Environmental Health Division

**6765 Gun Club Trail, AL-21-20**

Please accept the following comments from El Paso County Public Health for the project referenced above:

Site Plan

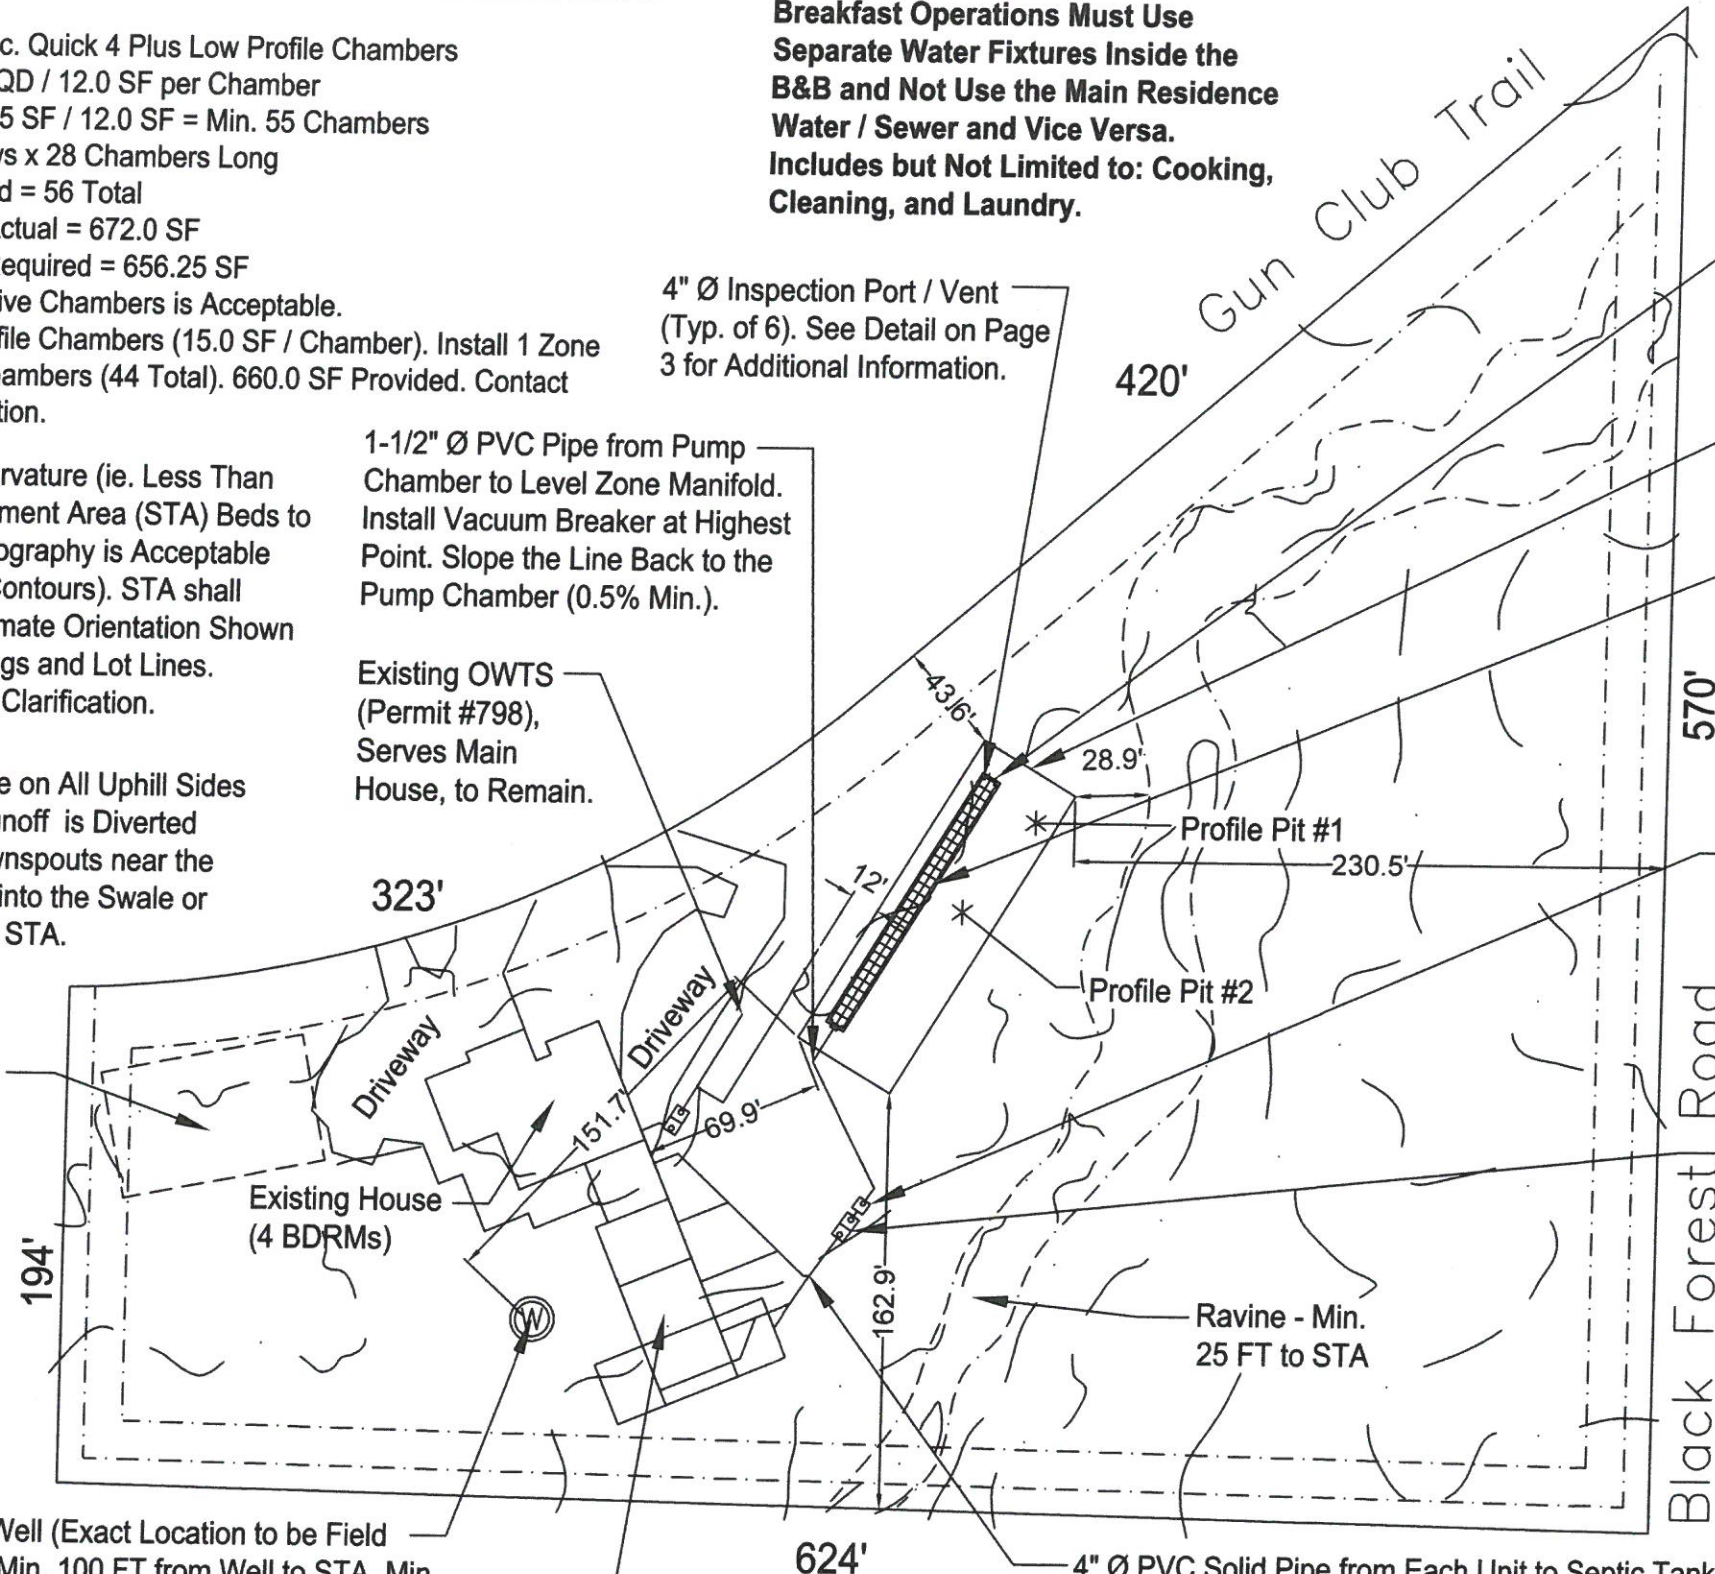
- Care must be taken to protect the proposed new soil treatment area (STA) from compaction during any remodel or parking area. We recommend the installation of temporary fencing to help identify and protect this future soil treatment area.
